RFI

RFI #: 115
Date: 5/14/2012
Job: EB-02 Keller Springs Lofts
Phone: 877-777-5115

CC: Erik Earnshaw (Beeler Guest Owens Architects), Heath Parnell (Jordan & Skala Engineers, Inc.)
Subject: HVAC Supply Duct and Return Air Duct Locations

Drawing: M2.1, M2.2, M2.4, M2.6 and corresponding Structural sheets
Spec Section:
Cost Impact: None
Schedule Impact: None

SHEET NUMBER
M-2.1
E1 &
A1 UNIT
MECHANICAL

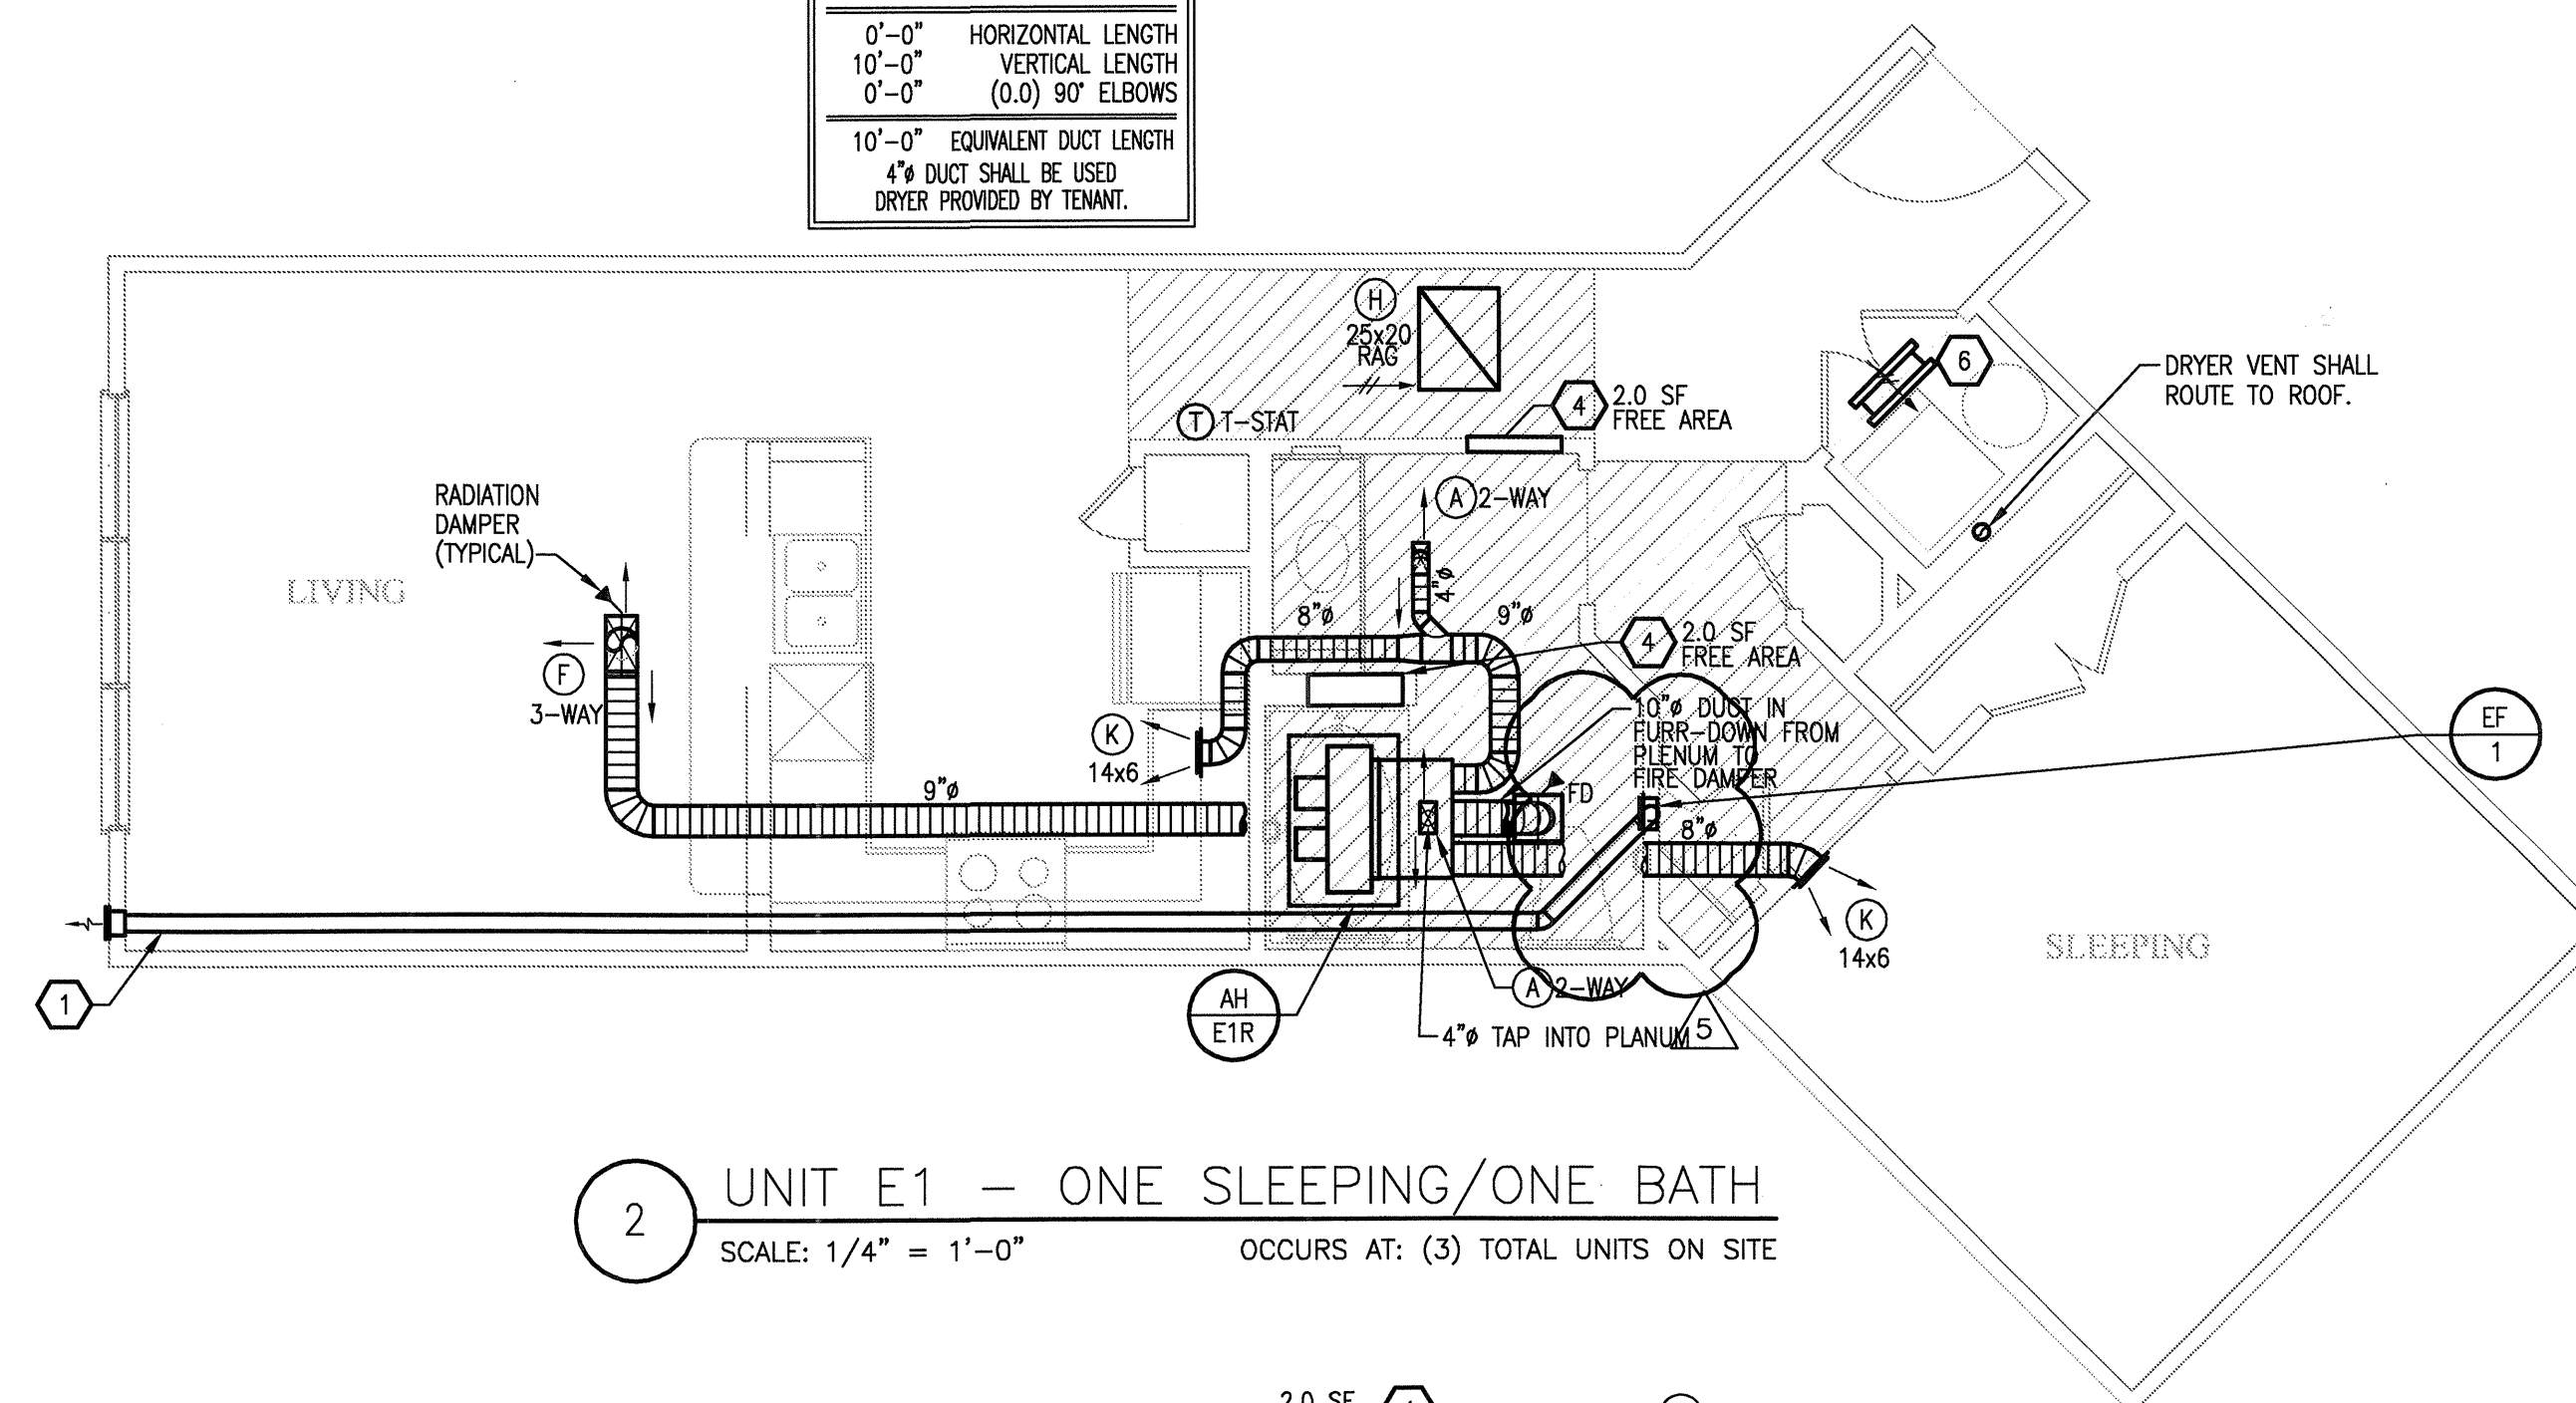
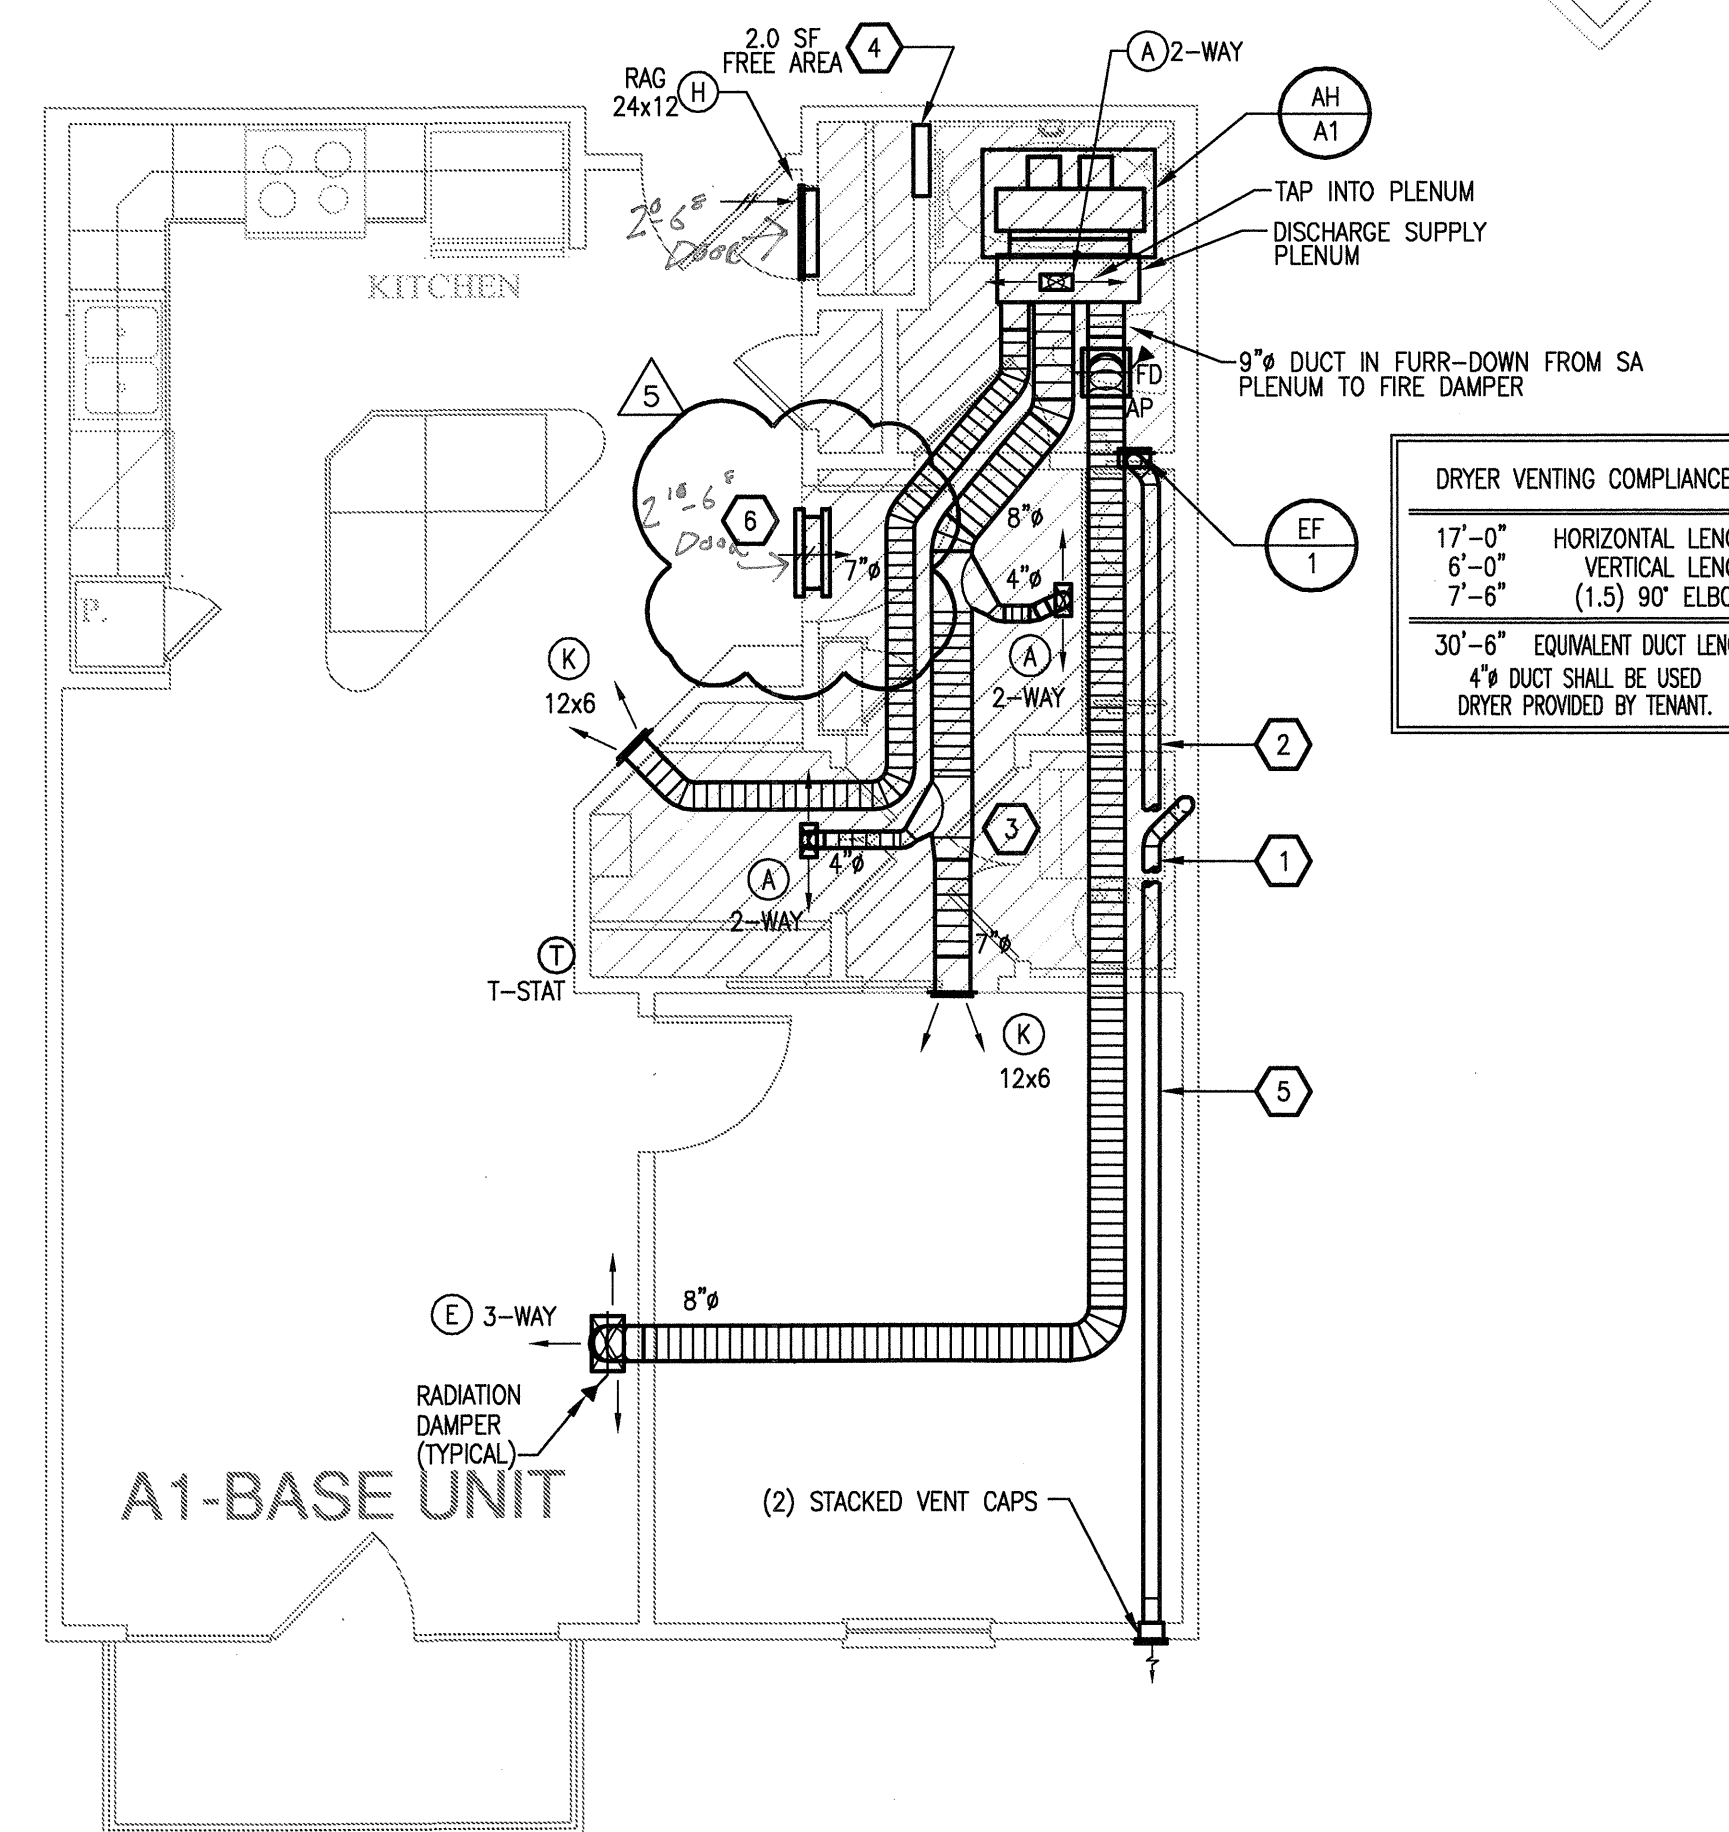
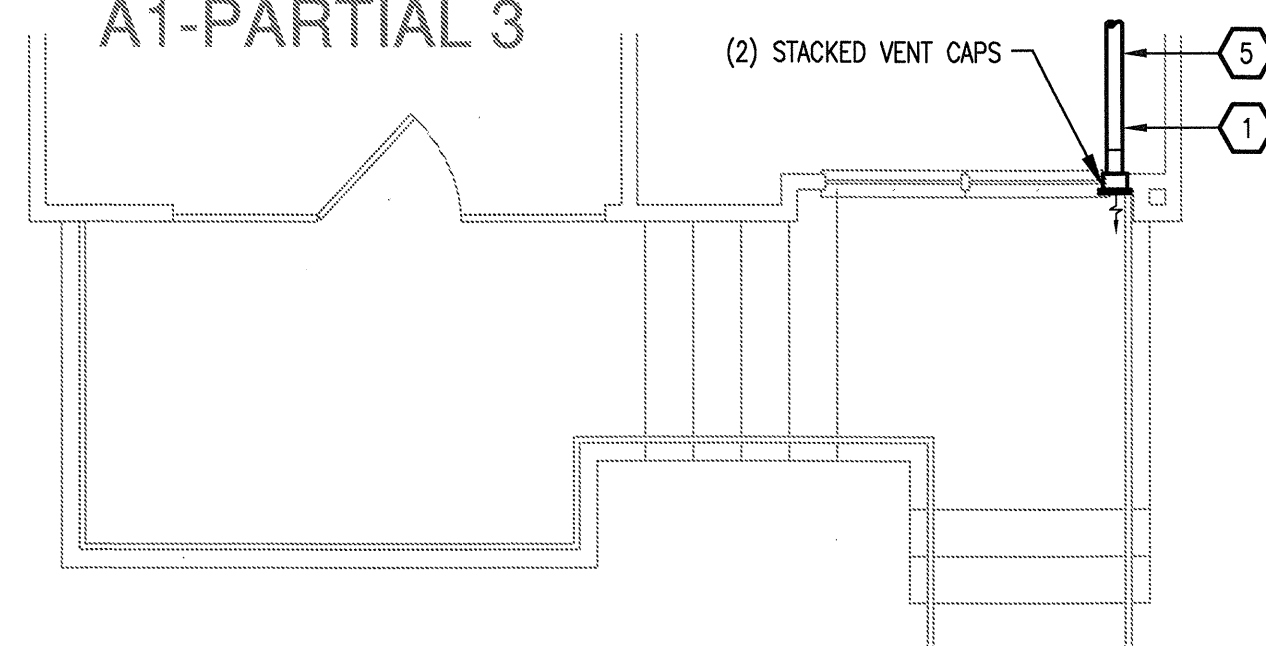
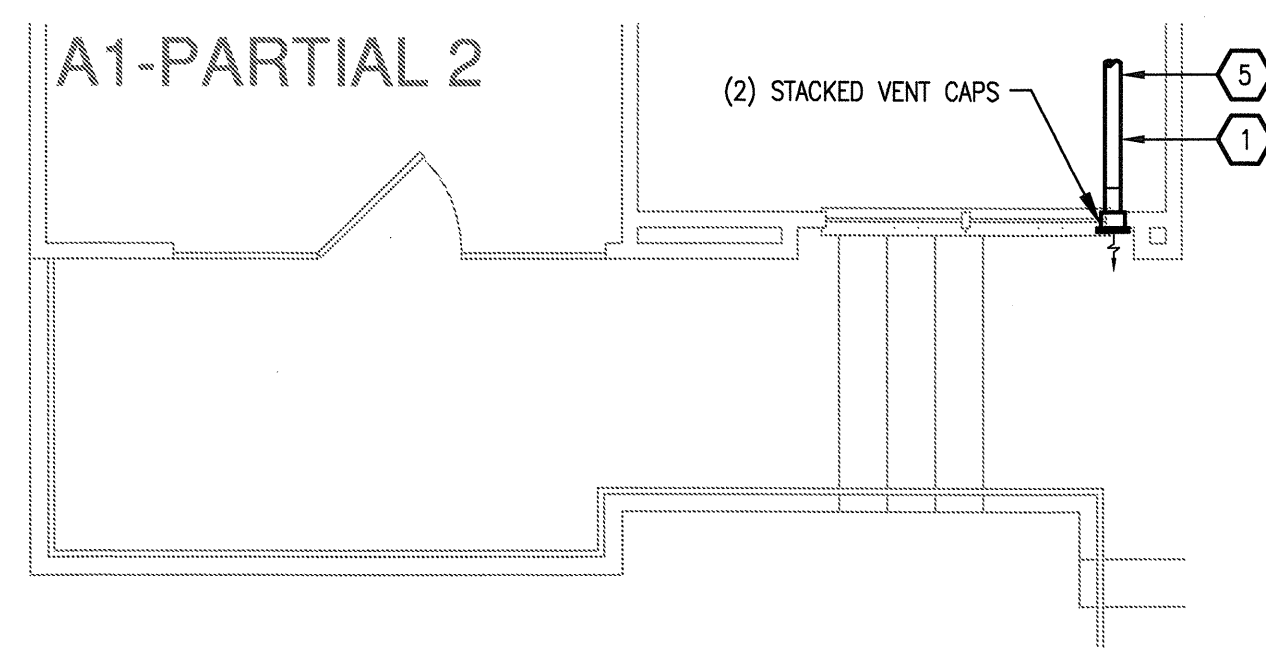
Request: **Date Required:** 5/22/2012
In the A1, A2, A4 and B2 unit types, there are either supply ducts or return air ducts terminating in a load bearing wall. Please provide a way to get around this issue.
Requested by: David Miller
Embrey Builders LLC

Refer question to Architect and/or Mechanical Engineer for additional requirements necessary for penetrating a load-bearing wall.
R. Trent Perkins, P.E. May 28, 2012
Parkin-Perkins-Olsen Consulting Engineering, Inc.

Provide a type A header where duct penetration will not fit between the stud wall framing.
R. Trent Perkins, P.E. May 29, 2012
Parkin-Perkins-Olsen Consulting Engineering, Inc.
